CITY OF ALBUQUERQUE

**RE: Manzano Mesa Park Pickleball Courts
Grading and Drainage Plan
Engineer's Stamp Date 2-1-16 (File: L21D037B2)**

Based upon the information provided in your submittal received 2-2-16, the above referenced submittal is approved for Grading Permit. Furthermore, we have the following recommendations to consider:

MANZANO MESA PARK
PICKLEBALL COURTS
GRADING & DRAINAGE DETAILS

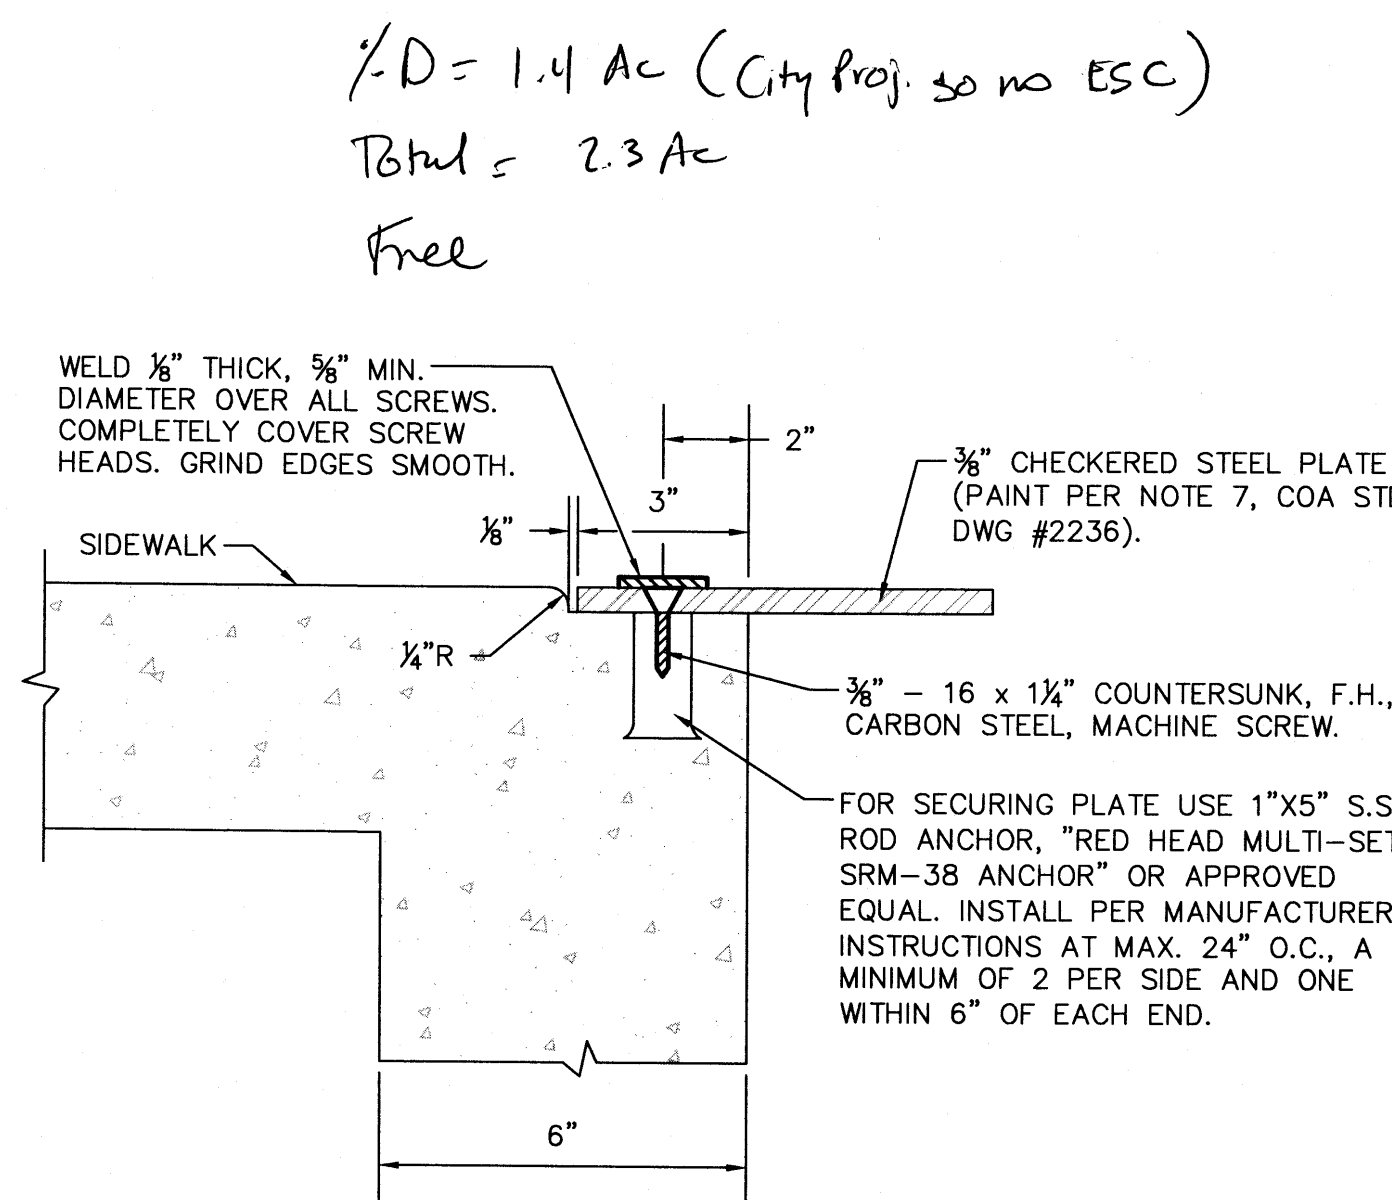
1. Consider an 18" sidewalk culvert (on Pond 2) to pass the approximately 7 CFS peak flow expected during the 100-year event. The 1-foot culvert appears to be acceptable, however, for the 2-year and 10-year events.
2. The City, as the lead of the project, might not be able to direct the contractor to sole-source drainage (or other) products (NDS, Geotex, etc). We recommend stating "or equivalent", or follow the guidance from the funding agency (if the project is federal or state funded).
